KITITAS COUNTY

MEMORANDUM

TO: All Staff
FROM: Public Works Plan Review Team
DATE: January 5, 2026
SUBJECT: SE-25-00019 Schmaus

SCHMAUS RESIDENCE
 SCHMAUS HAUS, LLC
 SITE PLAN

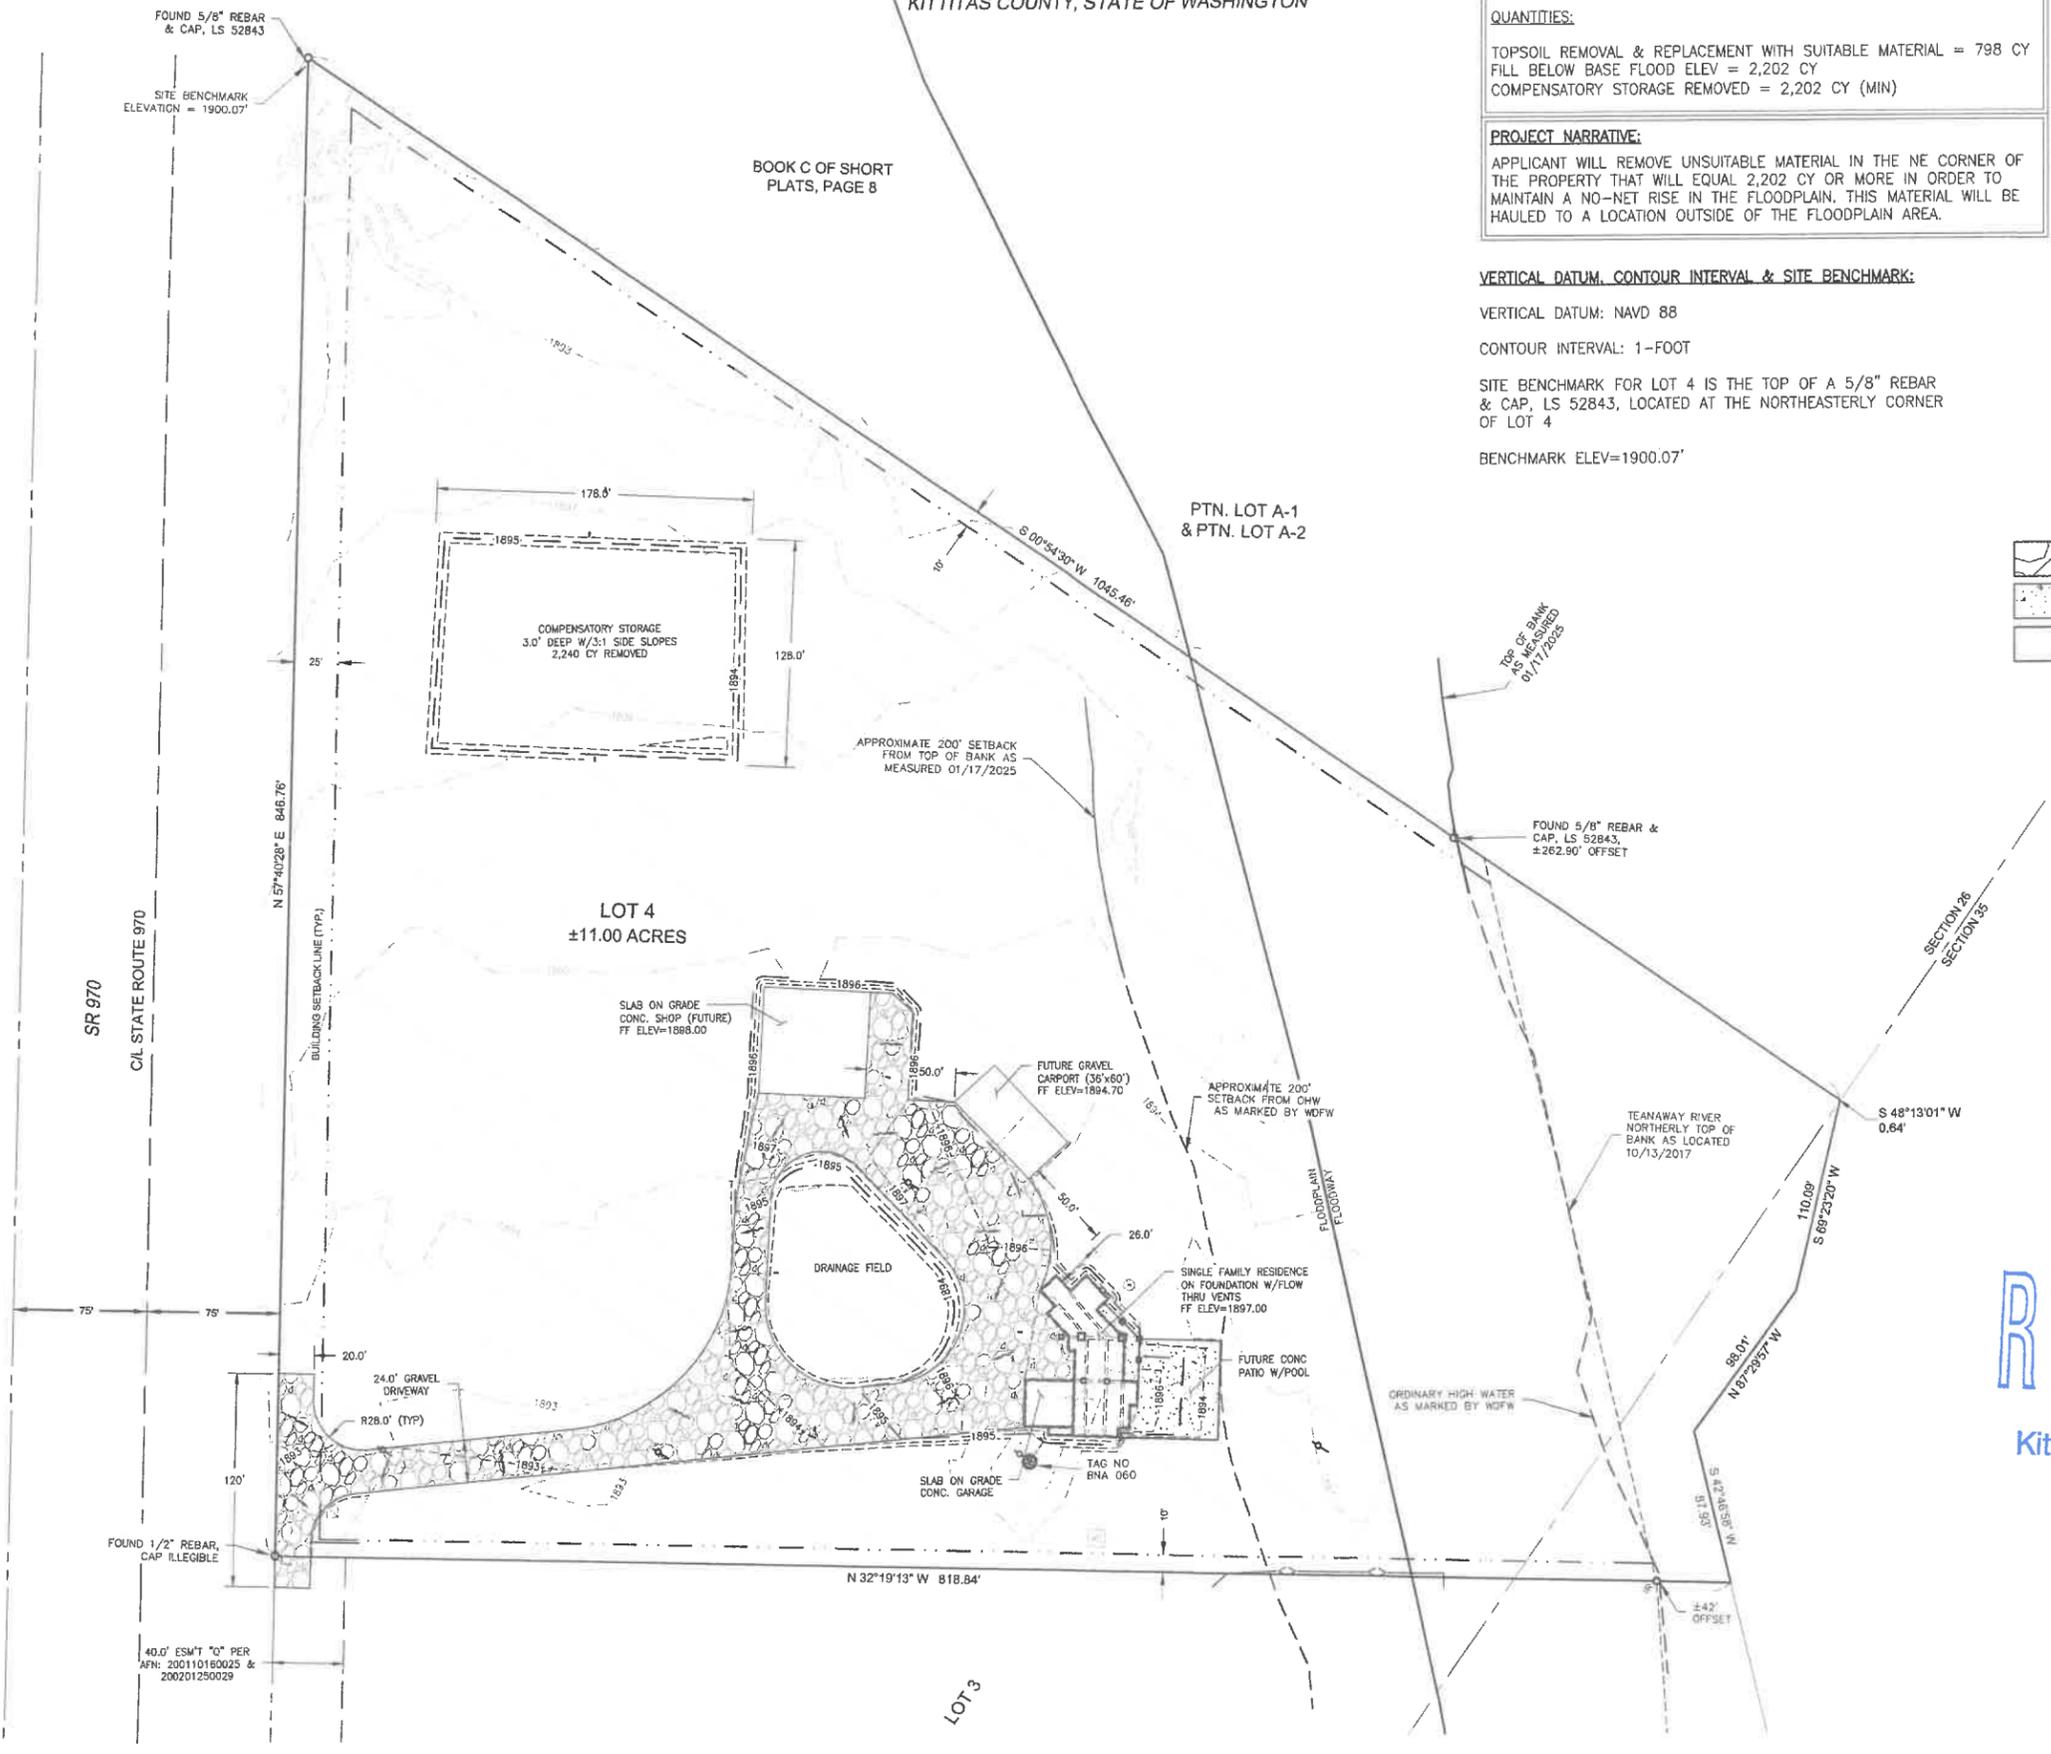
SURVEY	The proposed development includes installation of a gravel driveway over an existing property corner. If this corner is disturbed or destroyed by these activities, it shall be replaced by a land surveyor licensed to practice in Washington State. (JT)
TRANSPORTATION CONCURRENCY	No transportation concurrency management application required for this project as described. (KAH)

FLOOD	The proposed development requires a floodplain development permit and must meet KCC 14.08 requirements. Public Works has received a floodplain development application for the project (FD-25-00021) that is under review. The parcel contains FEMA designated floodway. Per the submitted site plan, the proposed development is located outside the floodway. Please be advised that the floodway is highly restricted and any development within the floodway boundary must be permitted through a floodplain development permit and must demonstrate no rise of 100-year flood elevations before being permitted. No new or substantially improved residences are allowed within the Floodway. (SC)
WATER MITIGATION/ METERING	No comments. (SC)
AIRPORT	No Comments. (RC)
